Open Floor Hearing Submission by Rebecca Walker on behalf of myself, Craig Walker and Tania Russell.

Outline Battery Safety Management Plan [APP-183]

*Figure C.2: Impacts from Unplanned Emissions at Eastern BESS Compound*

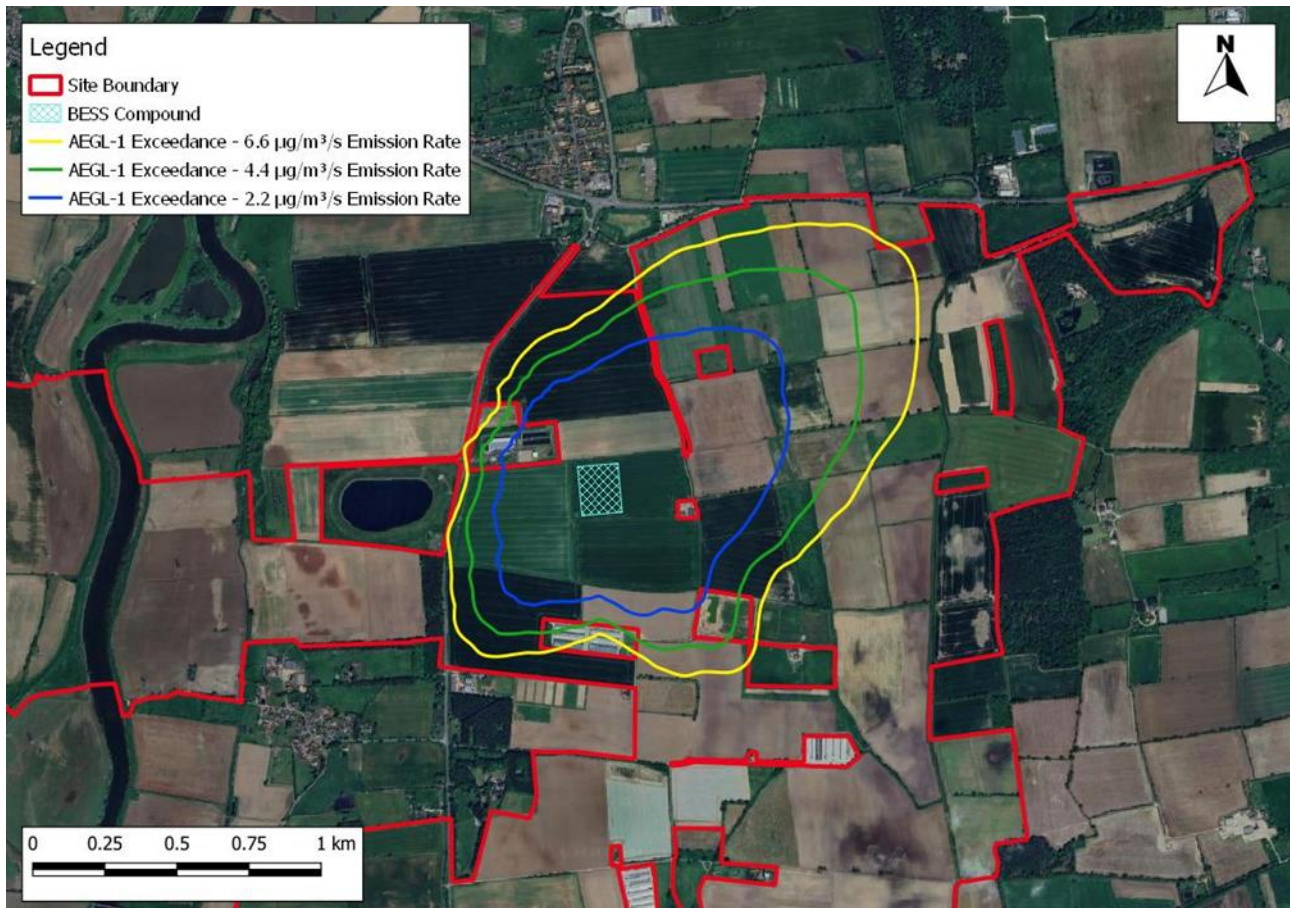
Whilst reviewing documents for information relating to the UKHSA. We note in [APP-183] it discusses the potential for Unplanned Emissions. On Page 60 under C.4.4.1 Results and Conclusions it states and I quote “as illustrated in Figure C.2, at the eastern BESS site, in all emission rate scenarios there are no sensitive receptors located within the area where the assessment level may be exceeded in 90% of meteorological conditions. Thus, it can be concluded that a fire at the eastern BESS site would not result in any significant adverse health effects.”

We would respectfully question if this statement is accurate. Looking on Page 61, Figure C.2: which shows a plan with the Impacts from Unplanned Emissions at Eastern BESS Compound, it is clear from the picture there are sensitive receptors within the marked areas, these being Northfield Farm Poultry Houses, Northfield Farm Bungalow and Anglian Water, Water Treatment Plant.

We also note the modelling was done on 3 and 6 hours of fire, which we assume has been undertaken following the required guidance, but when we know there are many cases of BESS fires where they burn for a lot longer, the modelling appears to be rather limited and likely best-case scenario. Surely something as critical as the spread of unplanned emissions is something that should be based on worst case scenarios.

*Figure C.3: Impacts from Unplanned Emissions at Western BESS Compound*

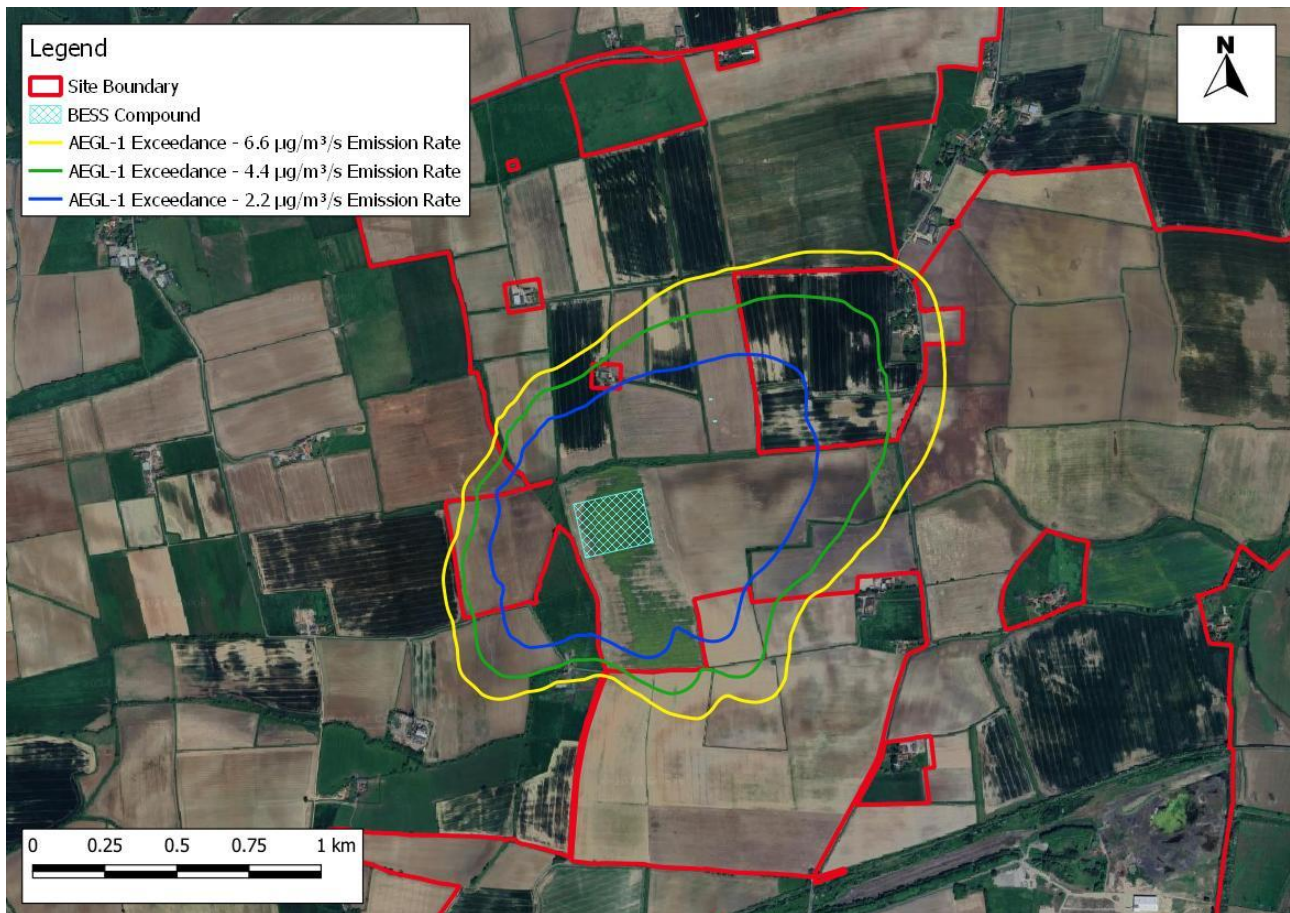
We would also point out for accuracy there is an error in [APP-183] with the labelling of Figure C.3 on Page 62 as it states it is the Eastern BESS compound, but we believe it is actually showing the Western BESS compound.
